PROJECT: WALDEN CORPORATION WWTP
 3155 WALKER ROAD COLORADO SPRINGS
 EL PASO COUNTY, COLORADO
 ENGINEER: AQUAWORKS DBO, INC.
 3252 WILLIAMS STREET
 DENVER, COLORADO 80205
 (303) 477-5915

SHEET TITLE:
 LAGOONS CLOSURE PLAN
 PROJECT NUMBER: #3774
 SCALE: 1"=100'
 SHEET: C10

V3_ Pond reclamation.pdf Markup Summary

SHEET TITLE:
LAGOON DECOMMISSIONING, GRADING AND RESTORATION
 PROJECT NUMBER: #3774
 SCALE: 1" = 80'
 SHEET: C12

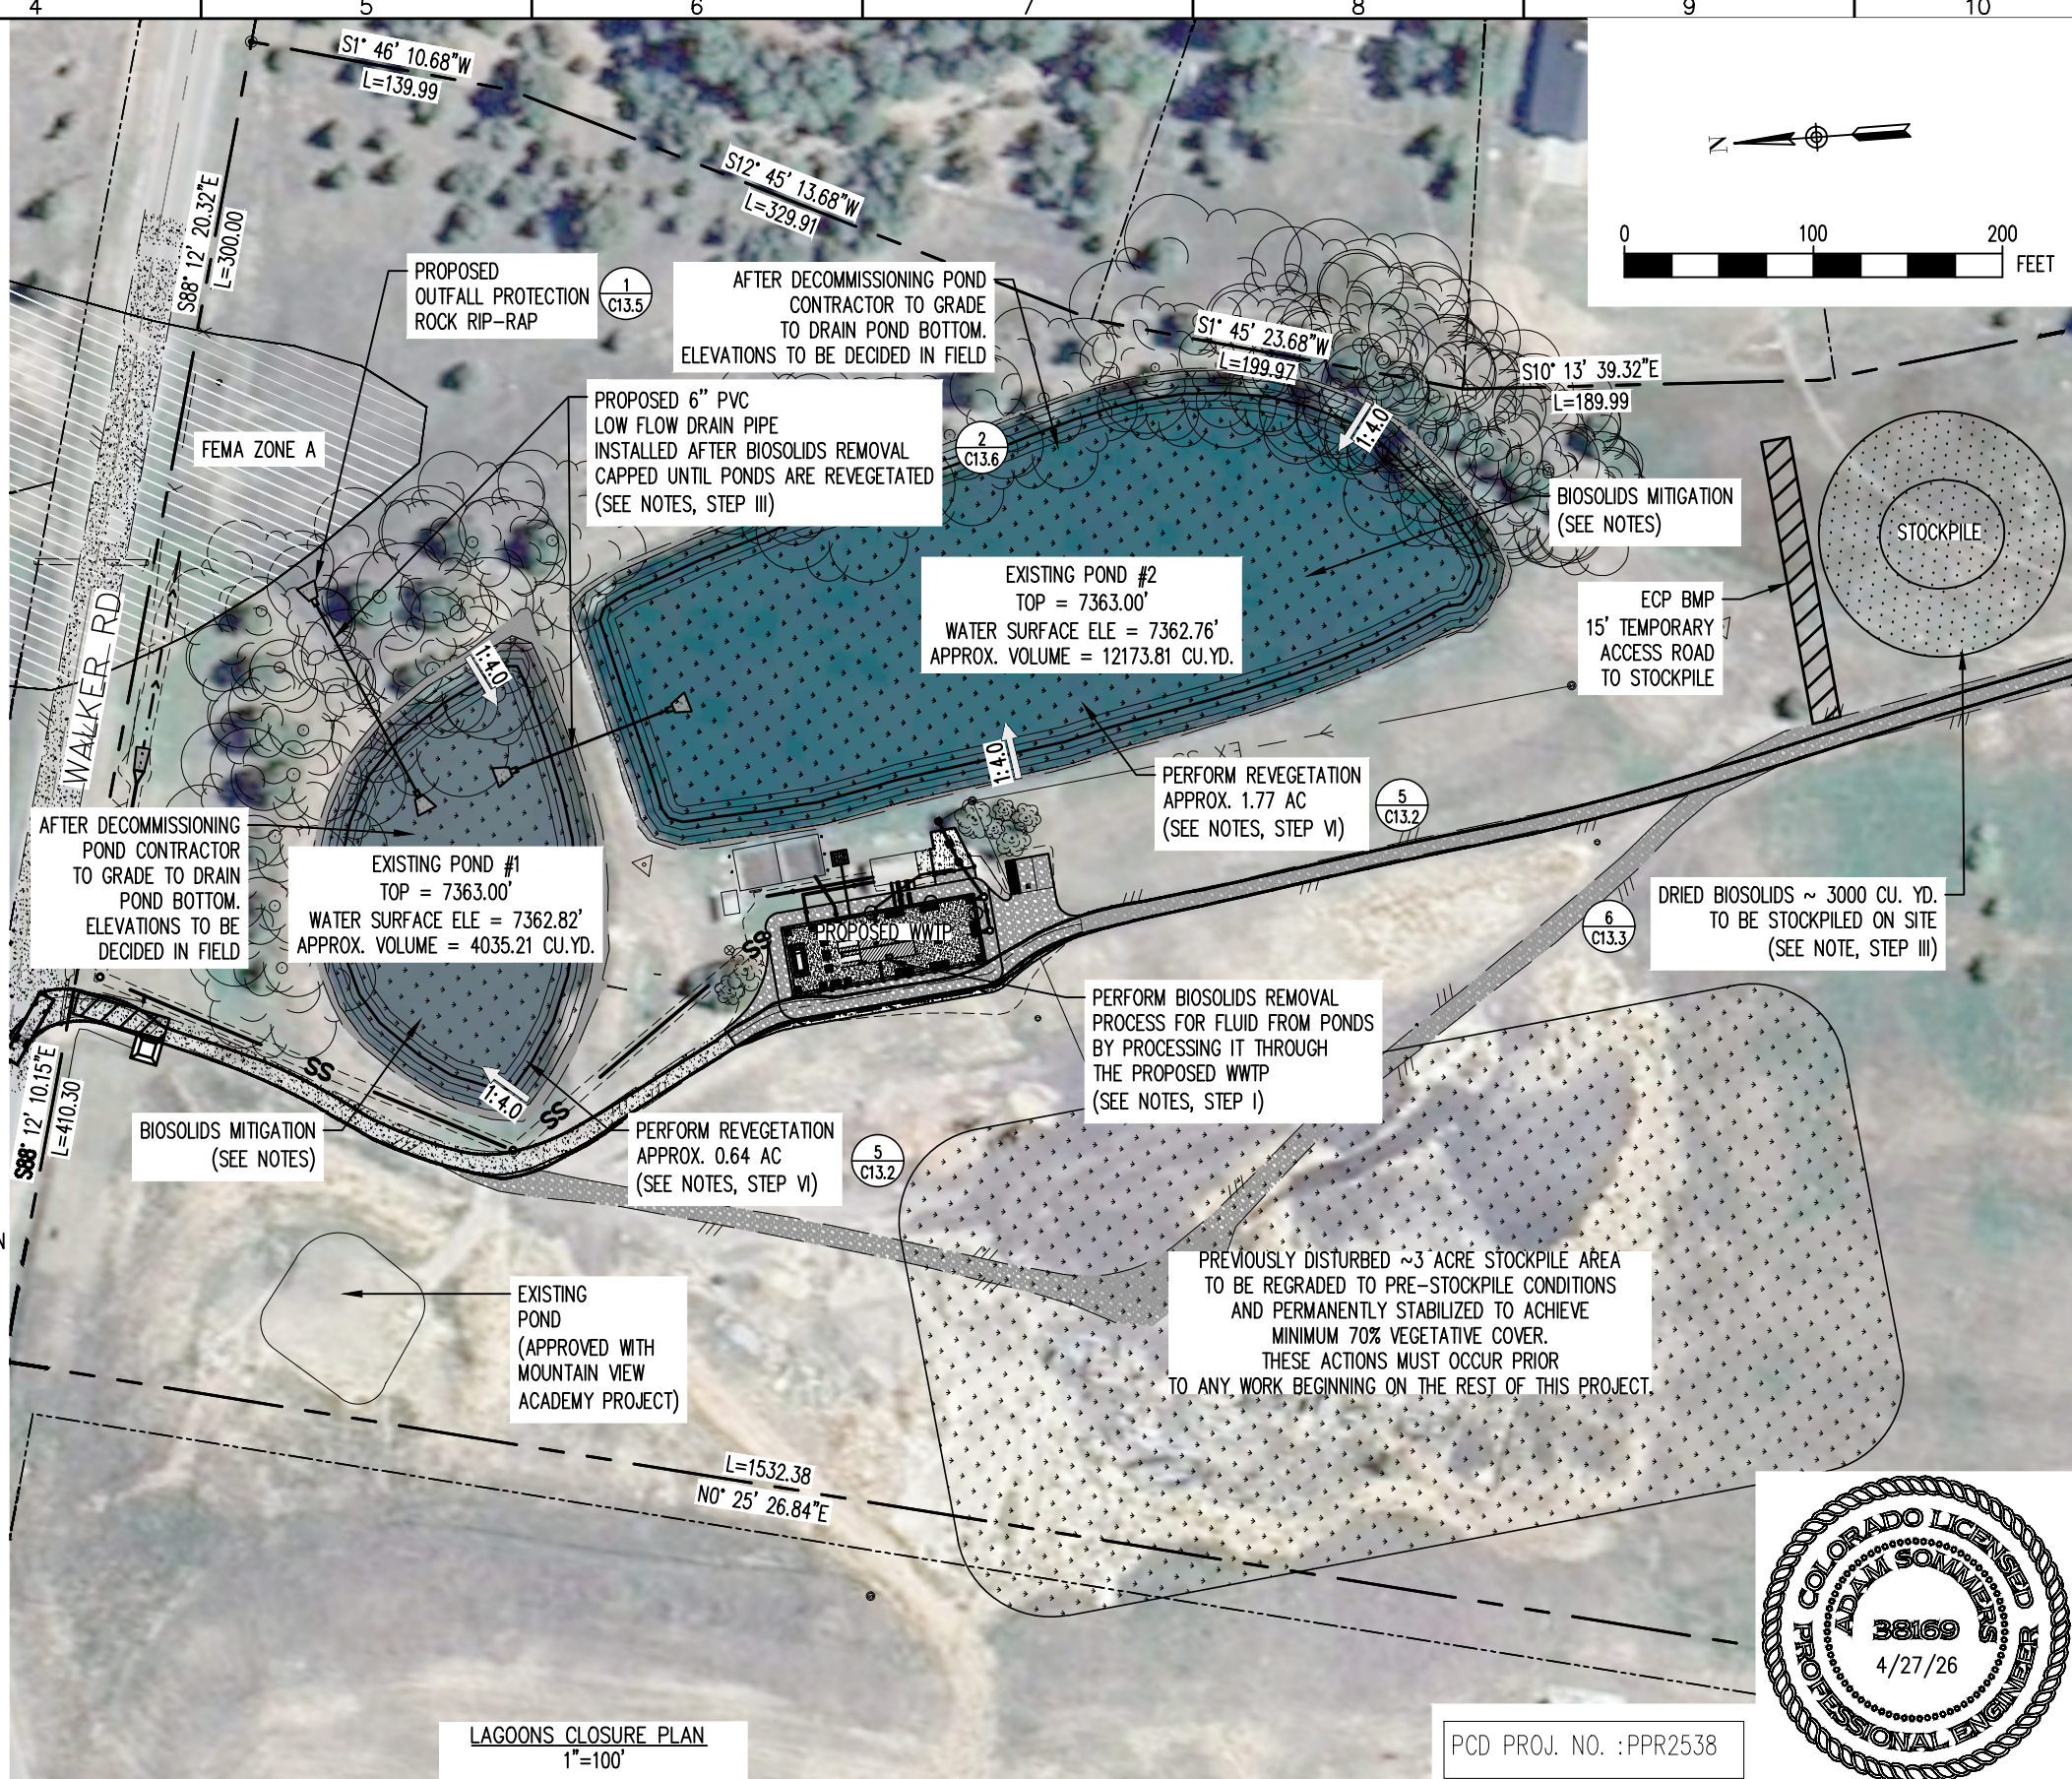
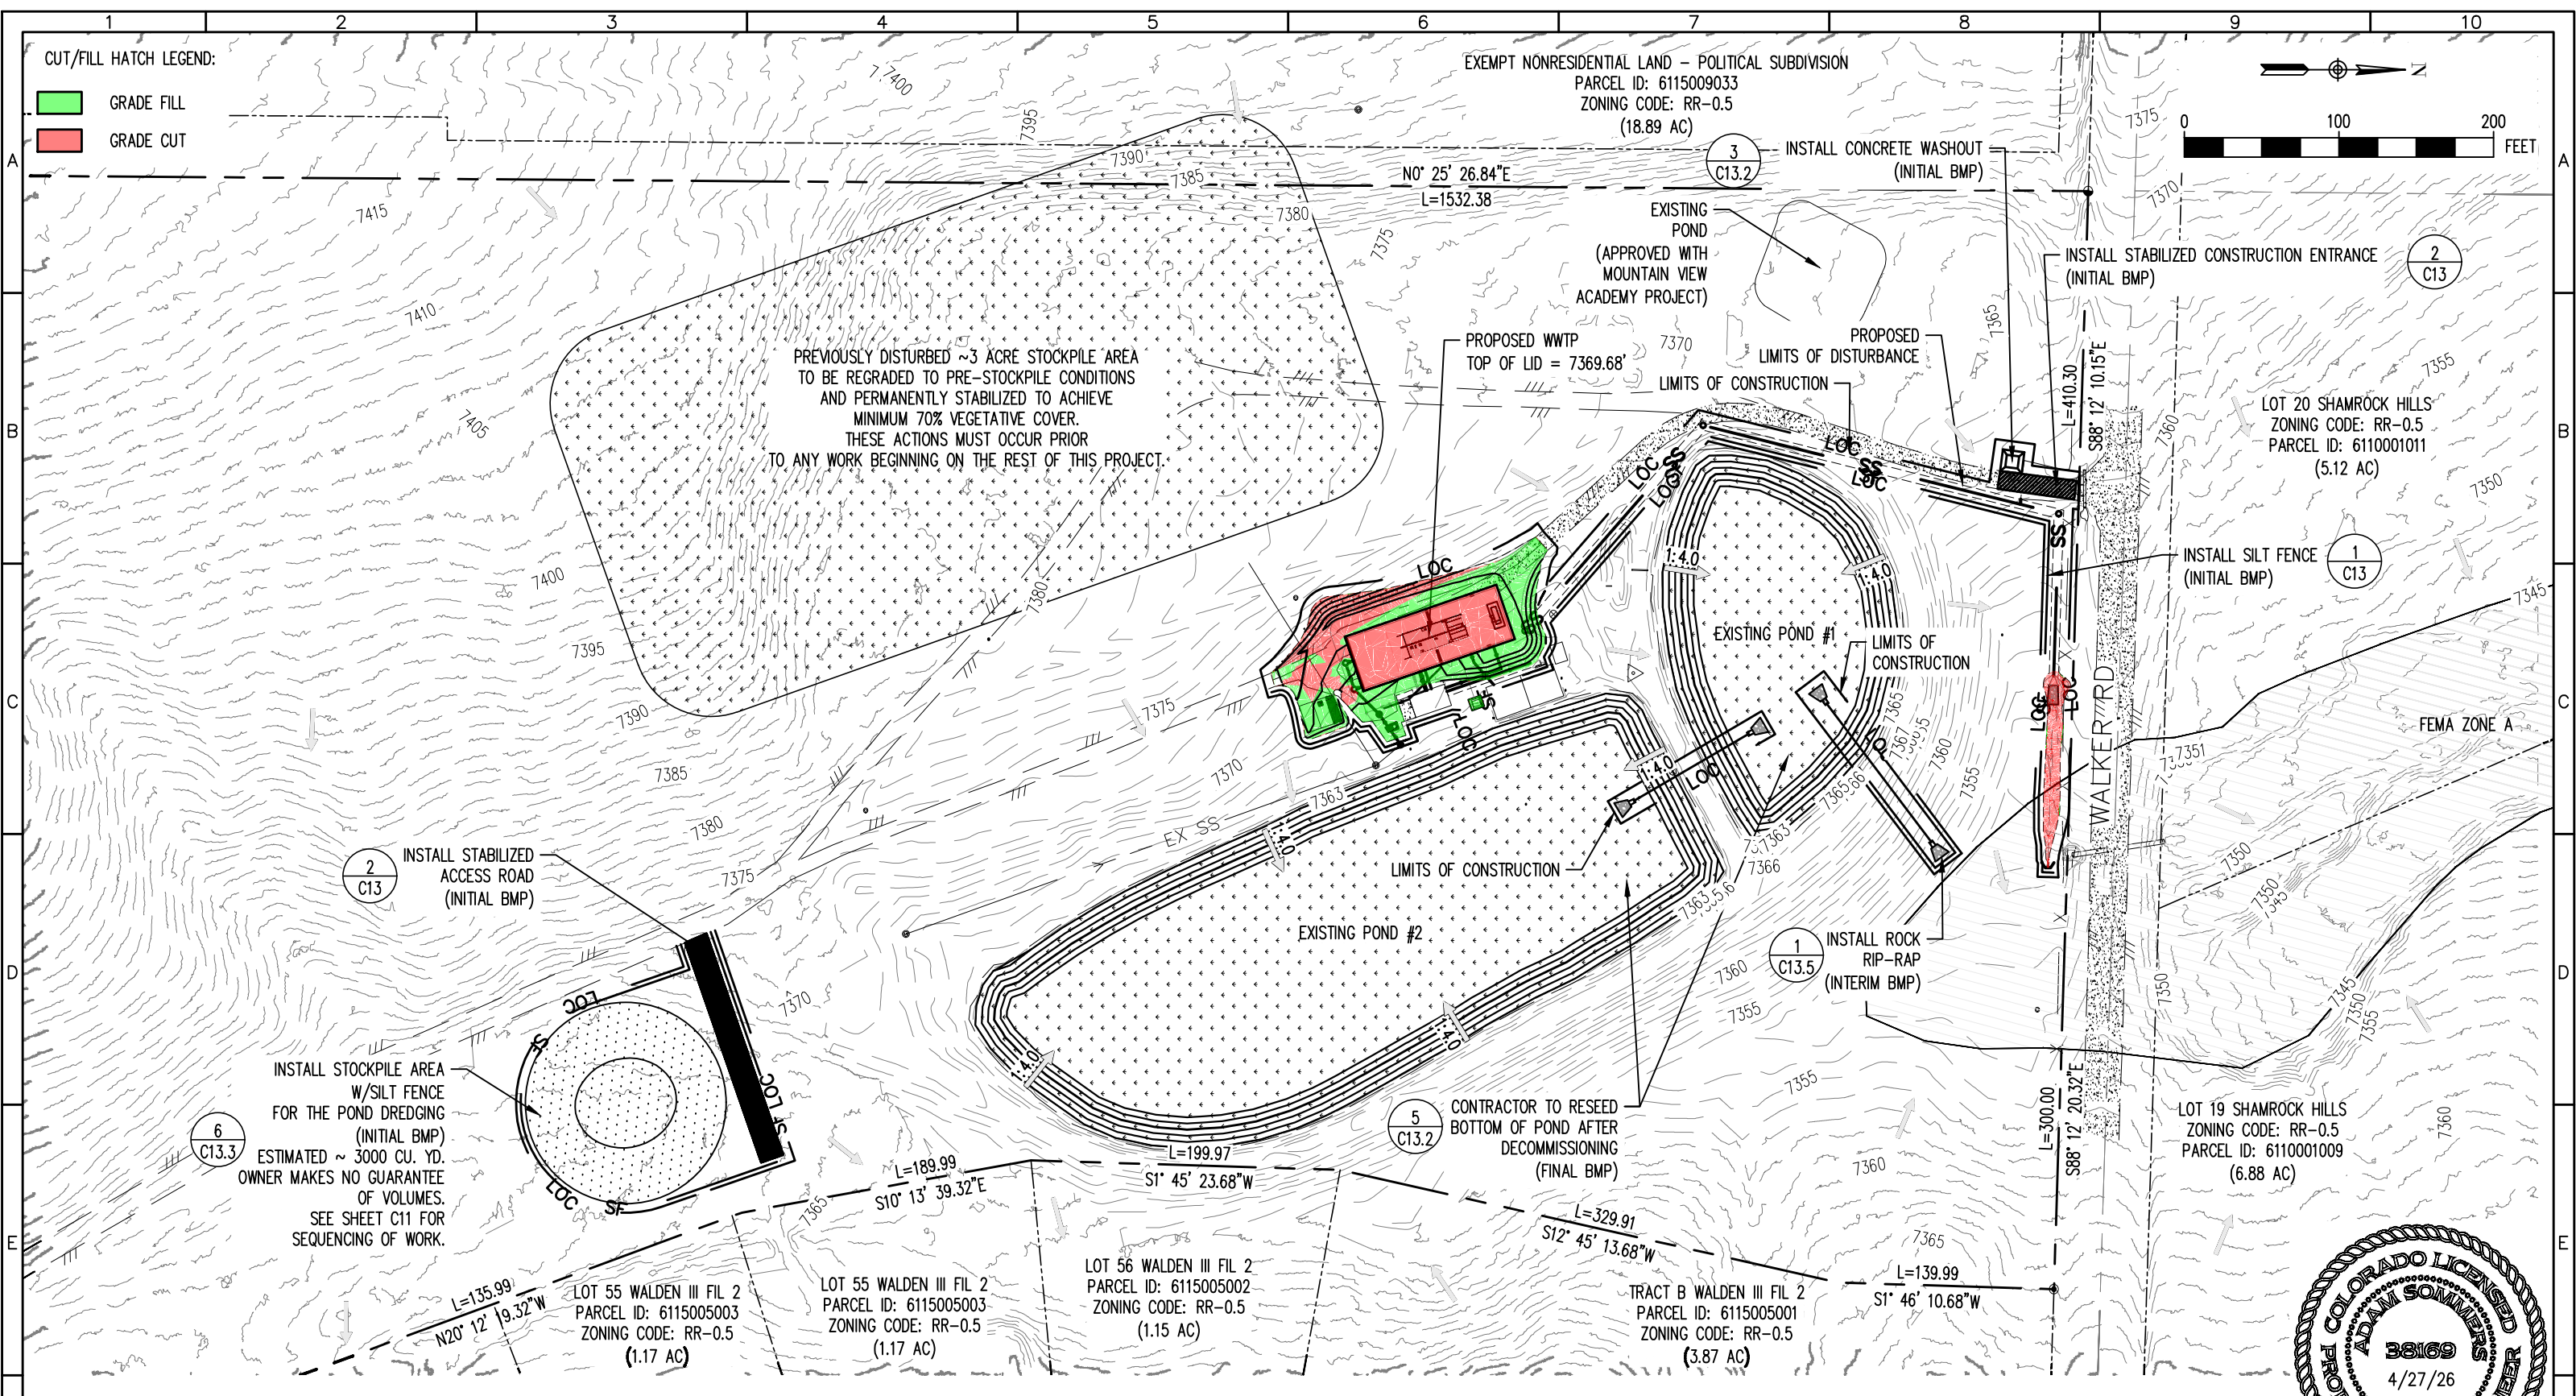
Show the anticipated dewatering operation on GEC plan and provide details.

See note on GEC plan. Reclamation plan must match GEC plan.

Please include a sheet of the pond in its final reclaimed state, including vegetation, pipes, and grading,
